CITY OF ALBUQUERQUE

Re: Rite Con Office
519 Oliver Ross Dr. NW
Traffic Circulation Layout
Engineer's/Architect's Stamp **05-30-2019** (K09D042)

Based upon the information provided in your submittal received 06-18-19 the above referenced plan cannot be approved for Building Permit until the following comments are addressed:

DRAWING TITLE: **SITE PLAN**

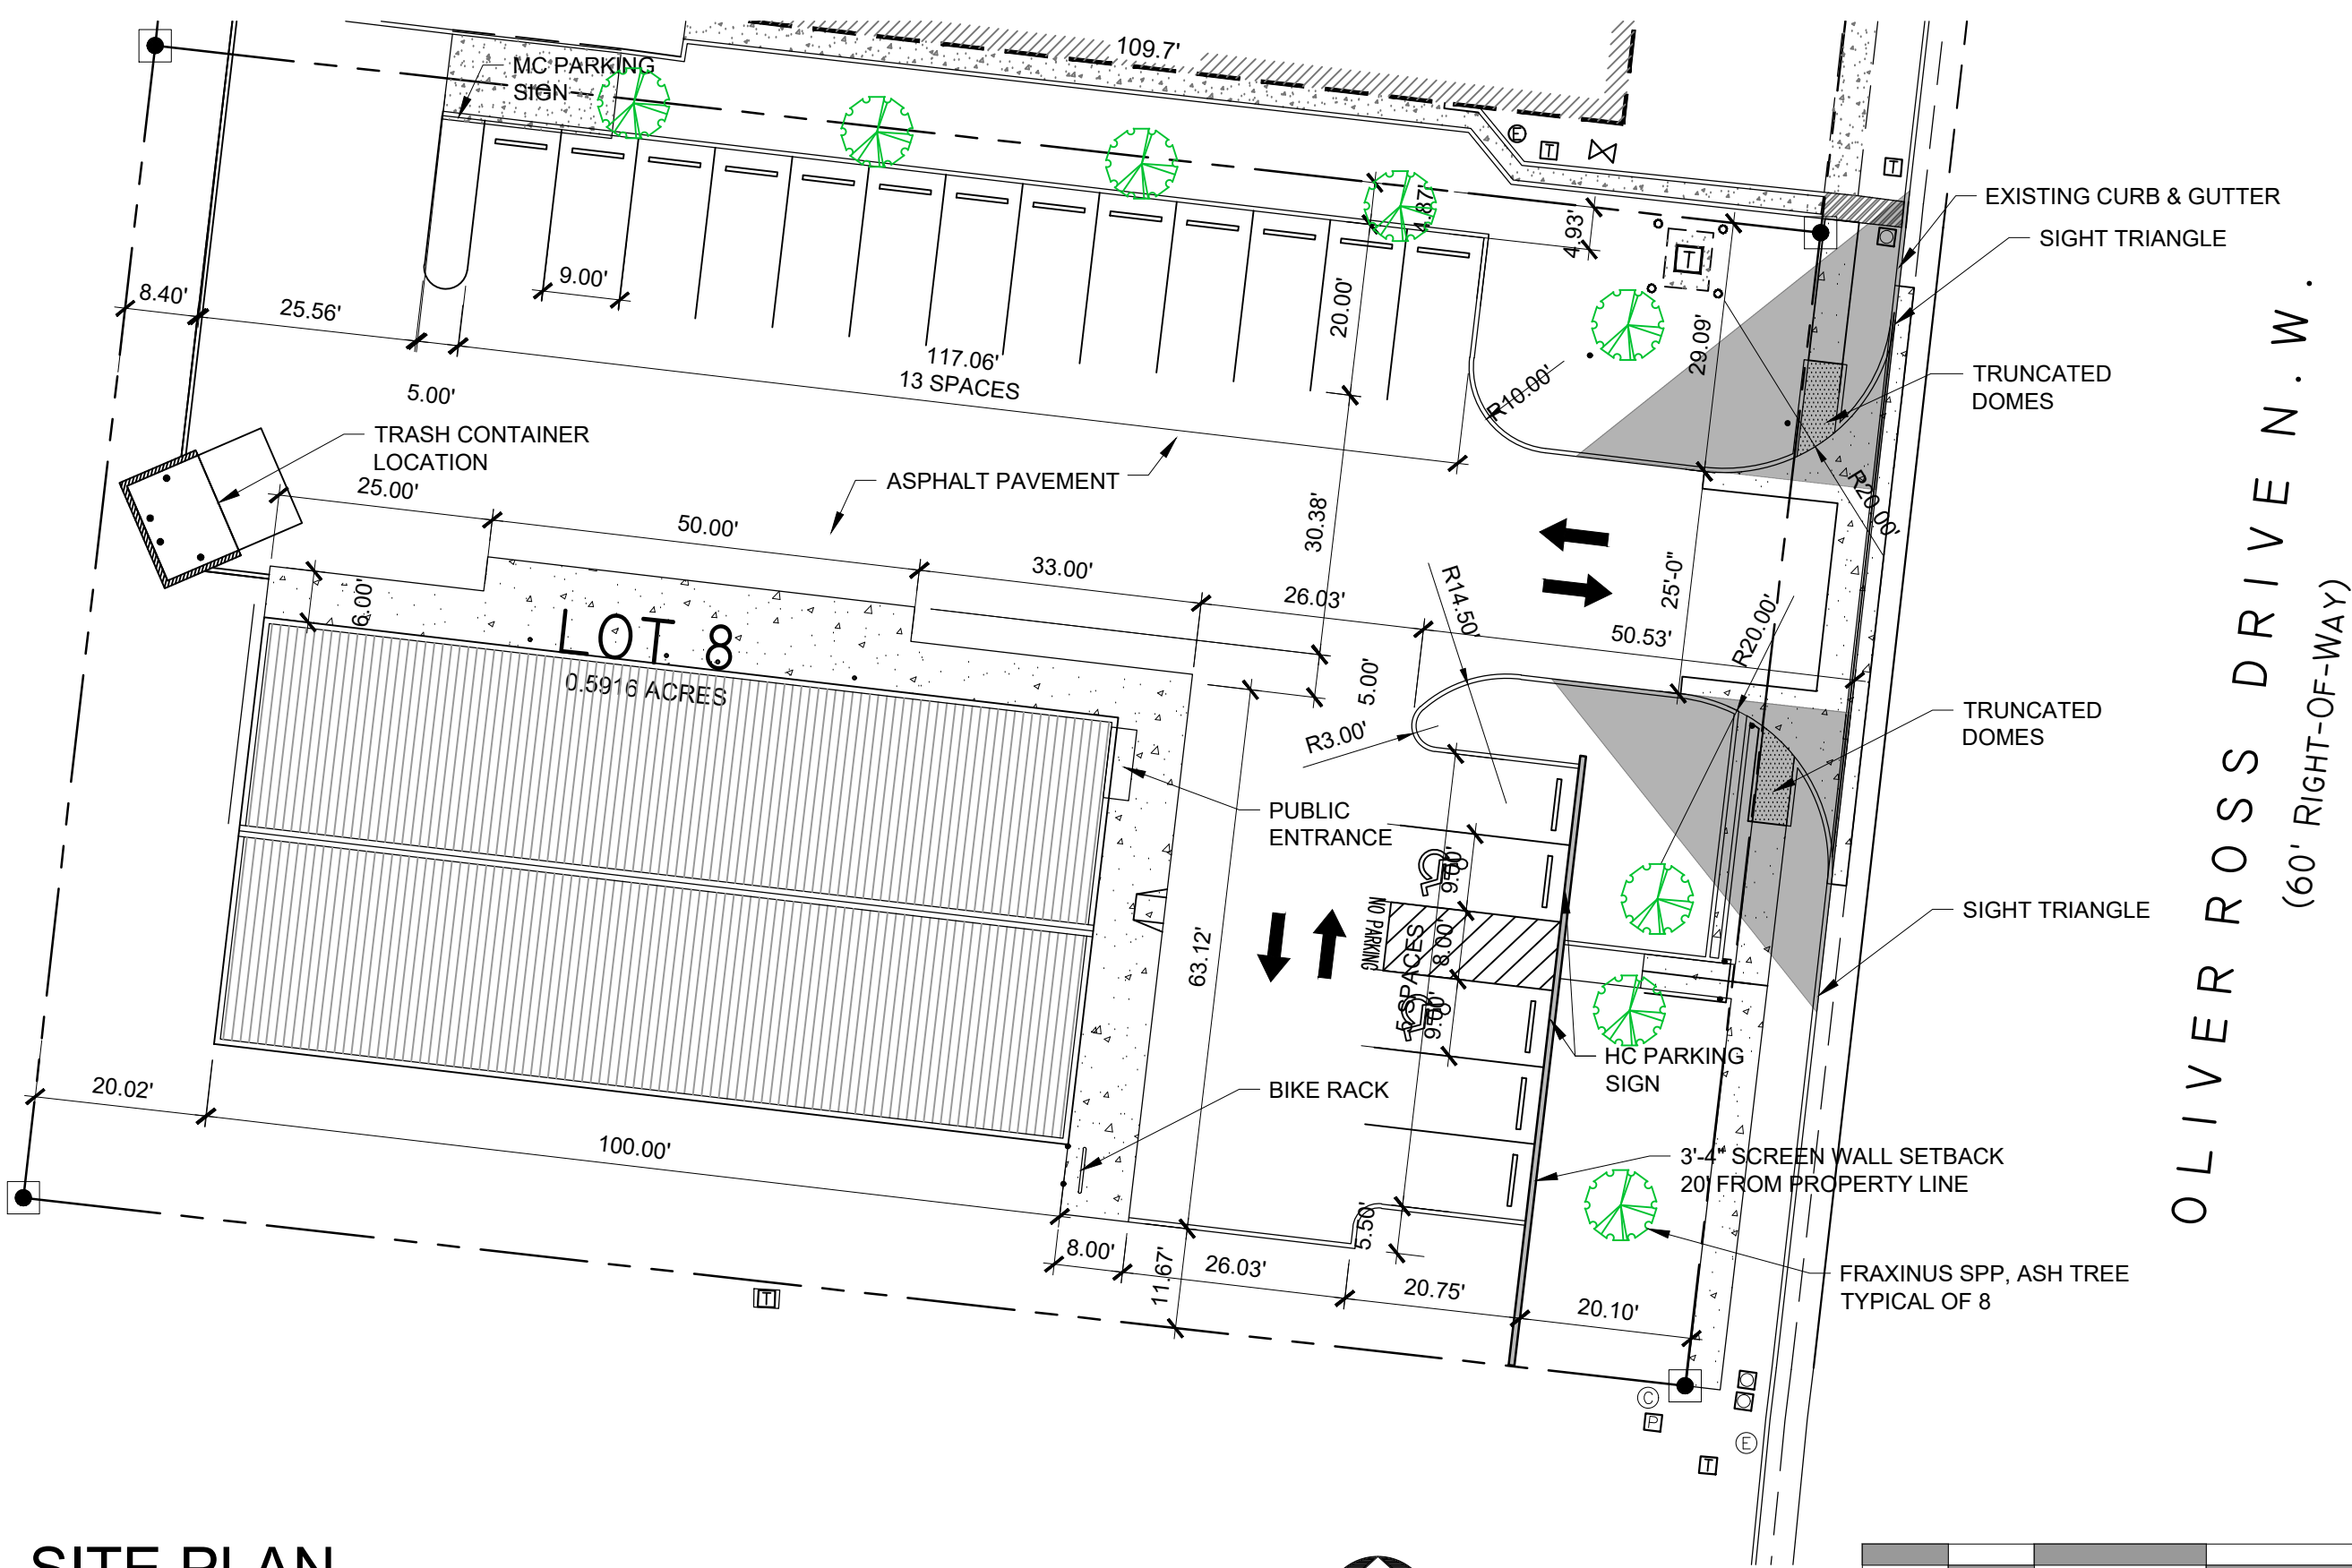
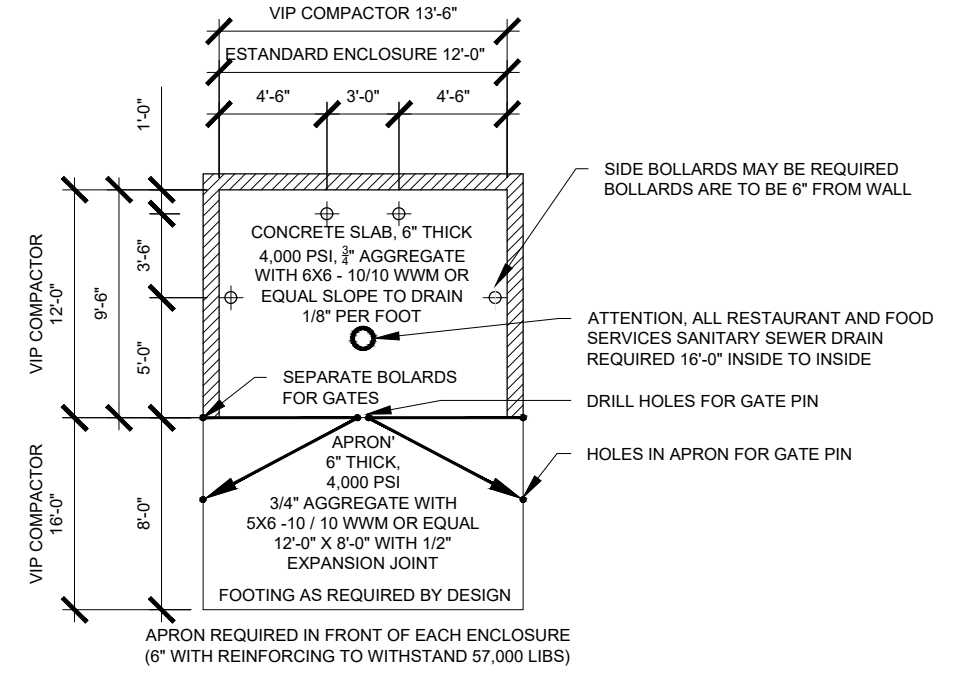
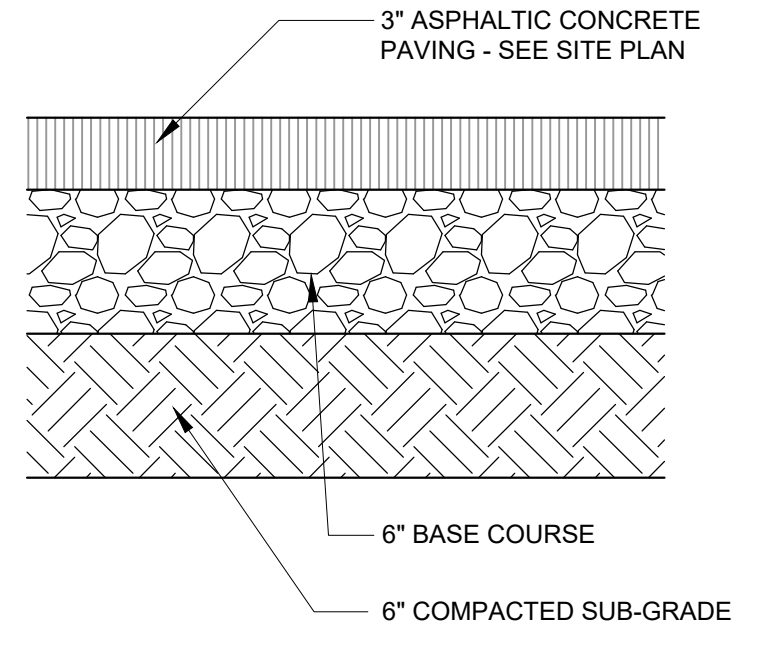
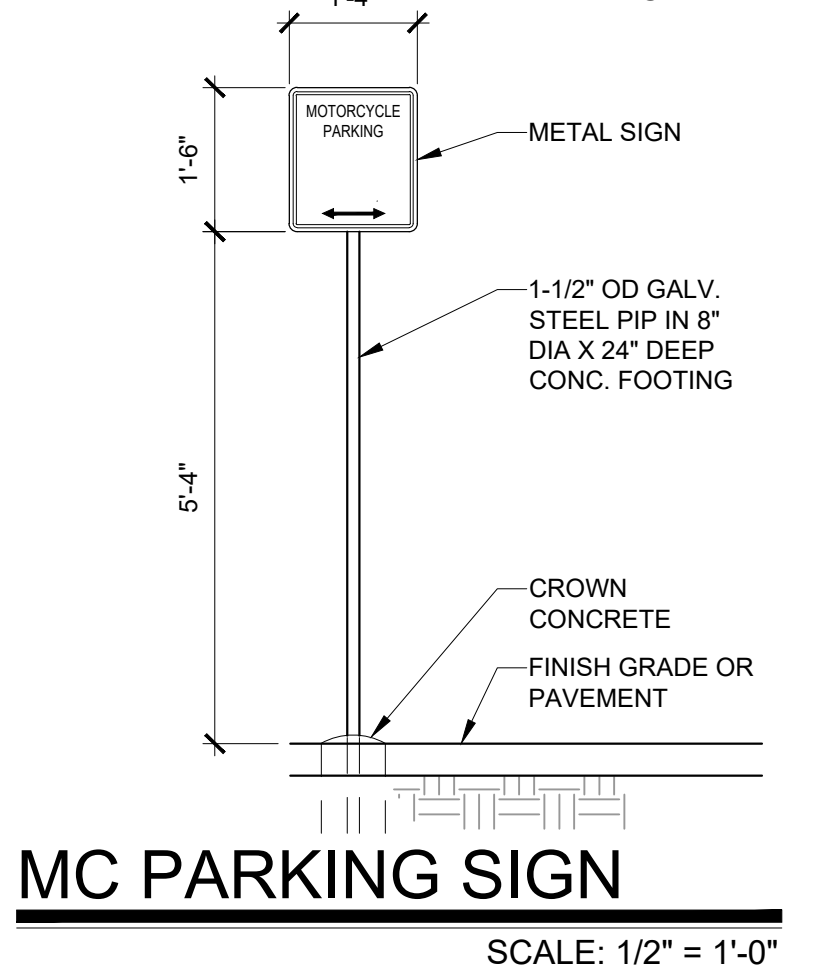
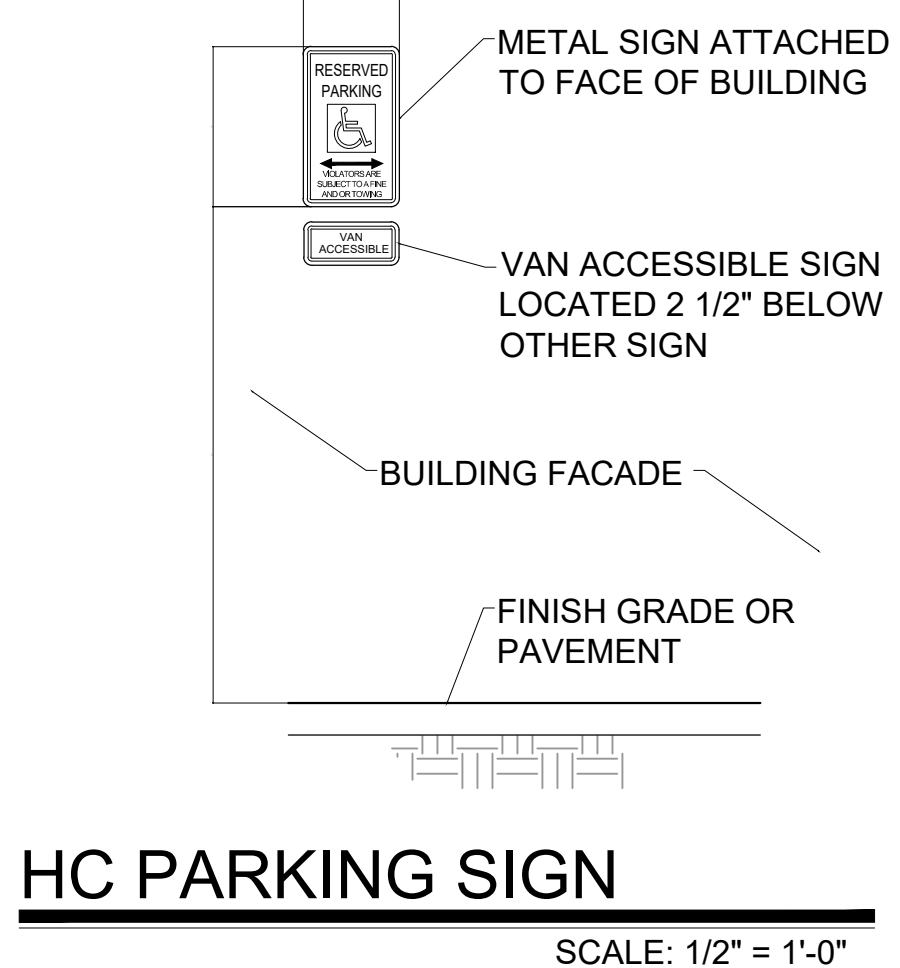
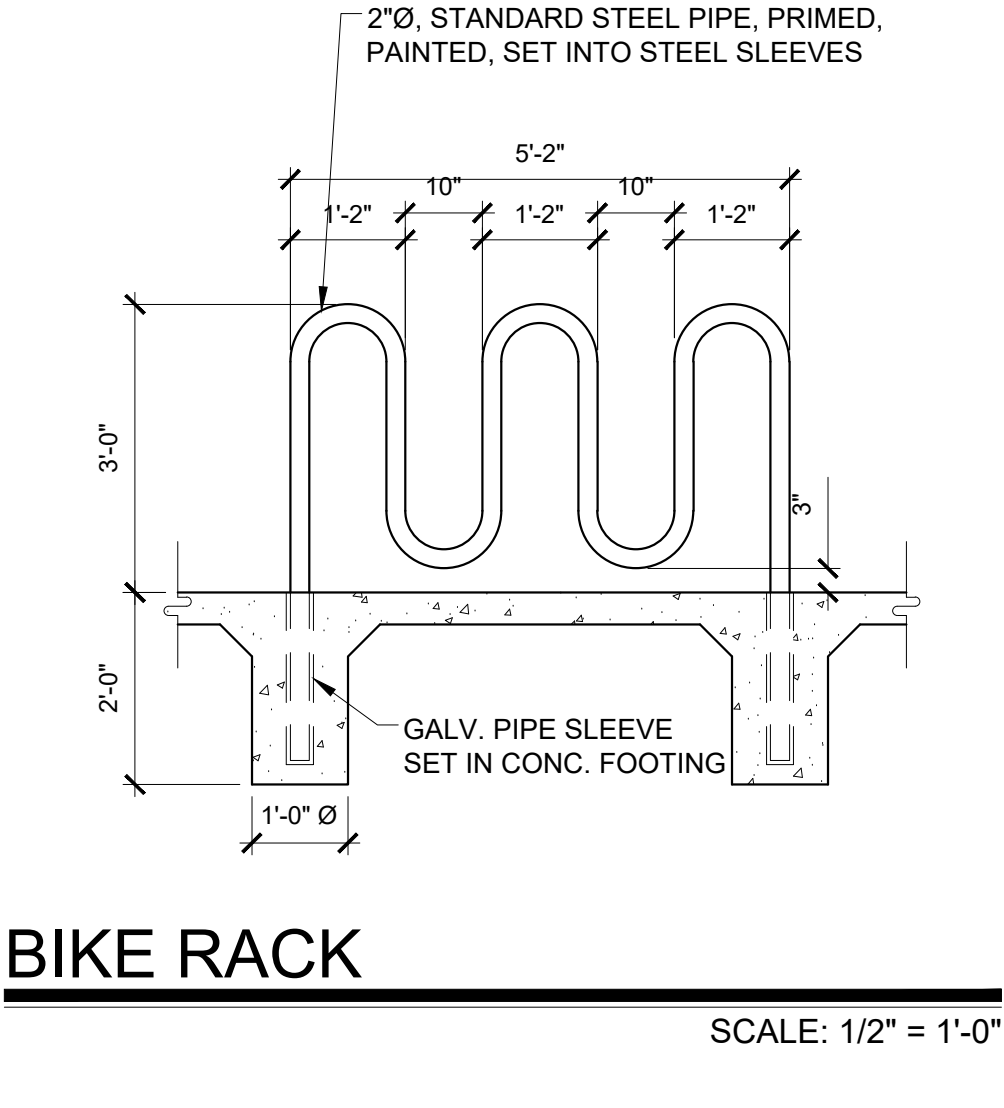
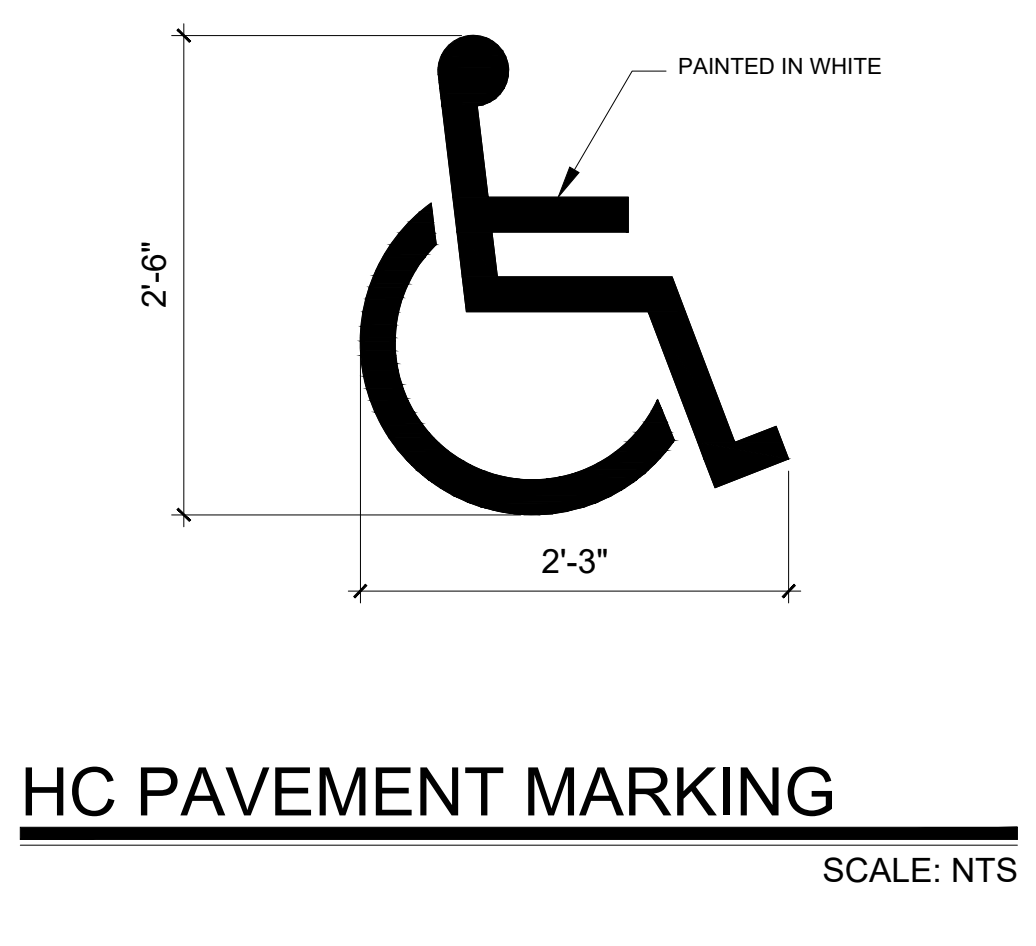
1. Per the IDO, a 6 ft. wide ADA accessible pedestrian pathway is required from the public sidewalk to the building entrances. Please clearly show this pathway and provide details.
2. Per DPM, a 6 ft. wide ADA accessible pedestrian pathway is required from the HC parking stall access aisles to the building entrances. Please clearly show this pathway and provide details.
3. provide a copy of refuse approval.
